Pagham Beach (Holdings) Ltd

5th February 2020

re. Town & Country Planning Act 1990 (as amended)
Application ref: P/117/19/PL
36 East Front Road, Pagham – proposed replacement dwelling

PROPOSED STREET
SCENE & BEACH
SCENE

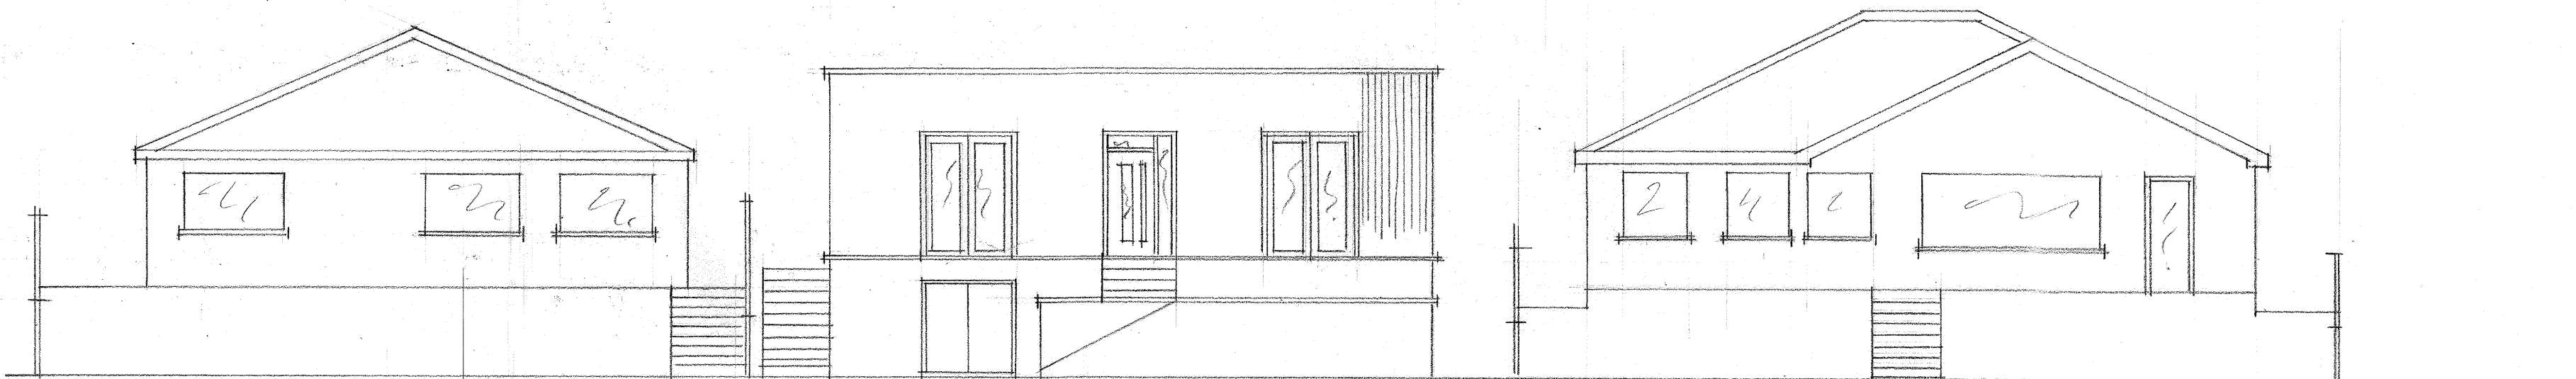
- The application site is situated on the Pagham Beach Estate which is defined within the Local Plan as an Area of Special Character. The application proposal as presented seem to completely disregard this designation.
- The application proposal is contrary to Policy D DM1 of the Arun Local Plan 2018 and seriously conflicts with adjacent the street scene.
- The application proposal would appear to be a serious overdevelopment of the site, with inadequate open/garden space which is contrary to the District Council's Local Plan.
- Although space for parking is shown on the Plan, the number of car parking spaces is not defined, and the applicant should be required to confirm that there is adequate on-site turning space within the site for vehicles. This is not evident on the current proposal.
